# KITTITAS COUNTY

## DEPARTMENT OF PUBLIC WORKS

**TO:** All Staff  
**FROM:** Public Works Plan Review Team  
**DATE:** August 29, 2022  
**SUBJECT:** CU-15-00002 Yakima River Campground

YAKIMA RIVER SHORT PLAT - SP 15-XXXXX
 A PORTION OF THE NORTH 1/2 OF SECTION 4,
 TOWNSHIP 19 NORTH, RANGE 16 EAST, W.M.,
 KITTITAS COUNTY, WASHINGTON

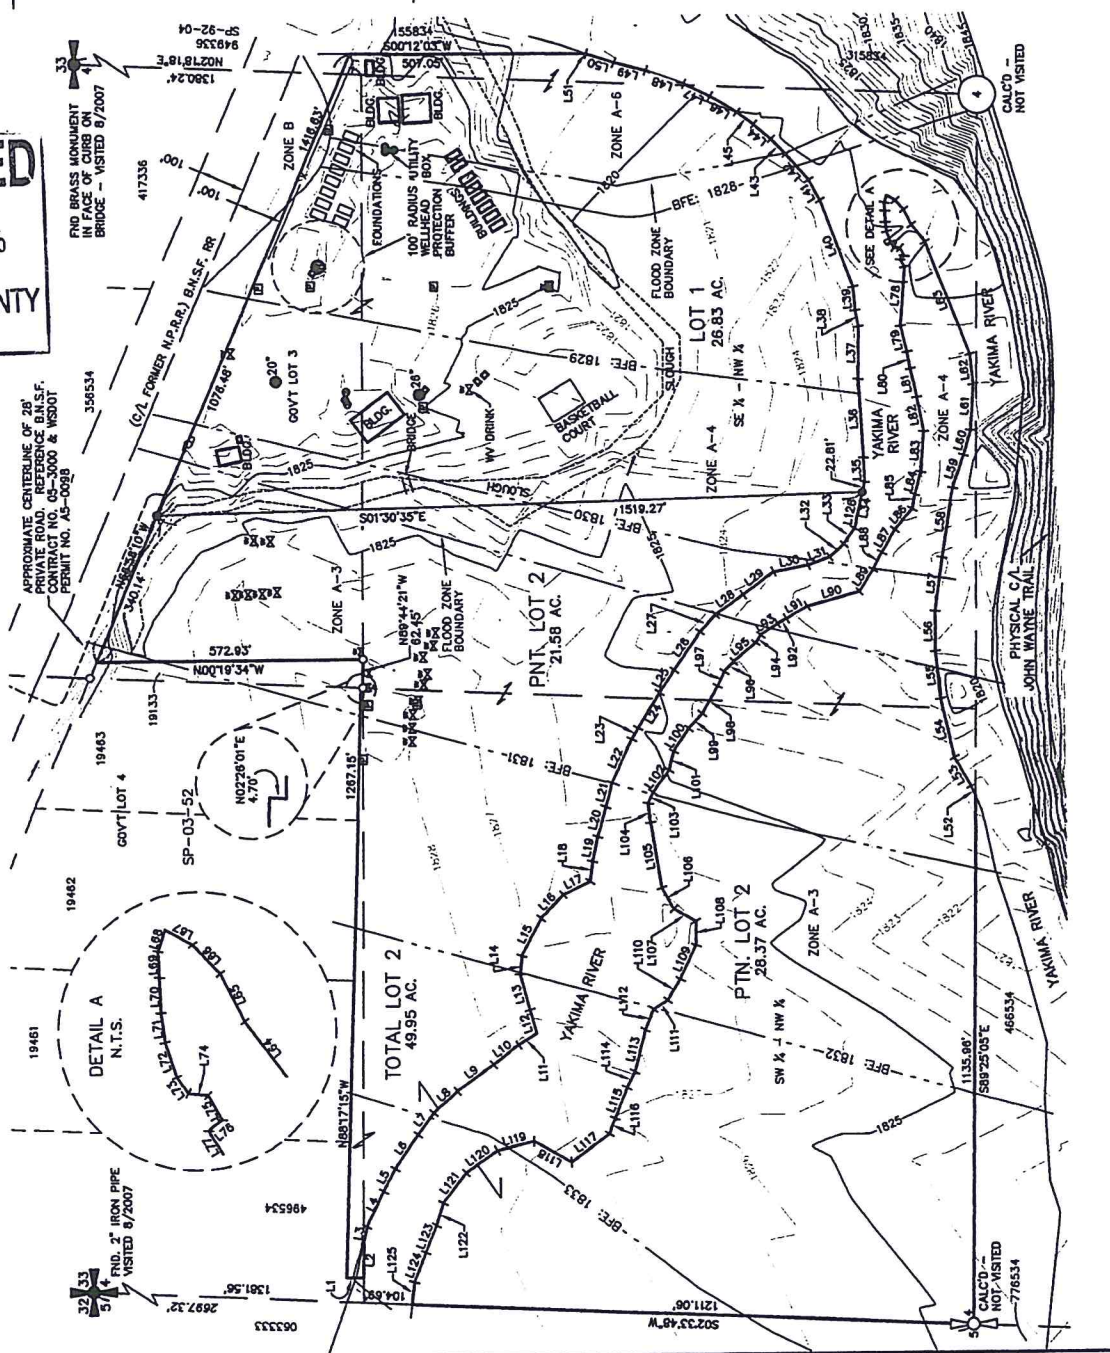
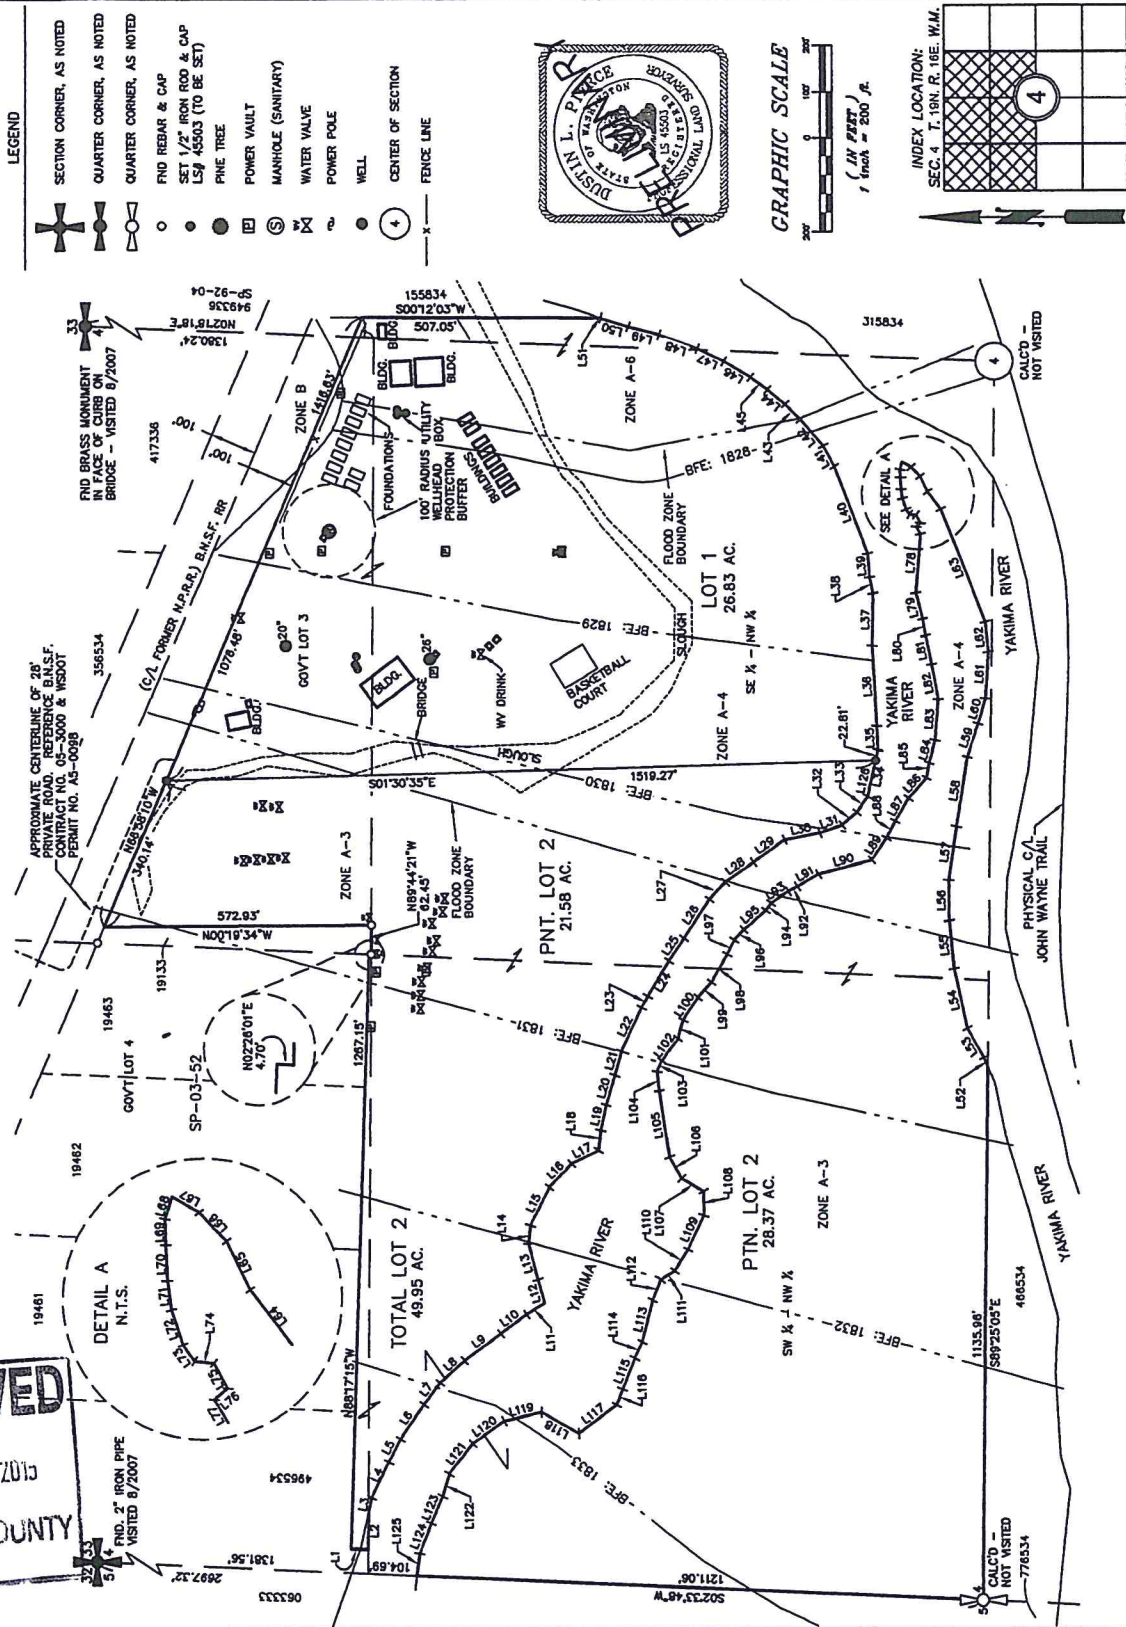
<p>4. All subdivisions shall show on the face of both the preliminary and final plat, for either short or long plats, the boundary of the 100-year floodplain and floodway.</p> <p>Additional information is required to evaluate consistency with KCC 14.08.220(1).</p> <p>Base flood elevation data is available at this location, satisfying: KCC 14.08.220(3).</p>
<p><b>WATER MITIGATION/ METERING</b></p>	<p>Prior to final plat approval and recording, the following conditions shall be met:</p> <p>In accordance with KCC Chapter 13.35.027, the applicant shall provide one of the following documents before final plat approval:</p> <ol style="list-style-type: none"> <li>4. A letter from a water purveyor stating that the purveyor has adequate water rights and will provide the necessary water for the new use;</li> <li>5. An adequate water right for the proposed new use; or</li> <li>6. A certificate of water budget neutrality from the Department of Ecology or other adequate interest in water rights from a water bank.</li> </ol> <p>All applicants for land divisions shall also submit information on "proximate parcels" held in "common ownership" as those terms are defined in WAC 173-539A-030 and otherwise demonstrate how the proposed new use will not violate RCW 90.44.050 as currently existing or hereafter amended.</p> <p>Failure to obtain mitigation before commencement of an activity requiring mitigation shall be a code violation subject to enforcement under Title 18 KCC.</p> <p><b>Final Plat Notes</b></p> <p>The following notes shall be placed on the face of the plat:</p> <p>C-1 “Metering is required for all new uses of domestic water for residential well connections and usage must be recorded in a</p>
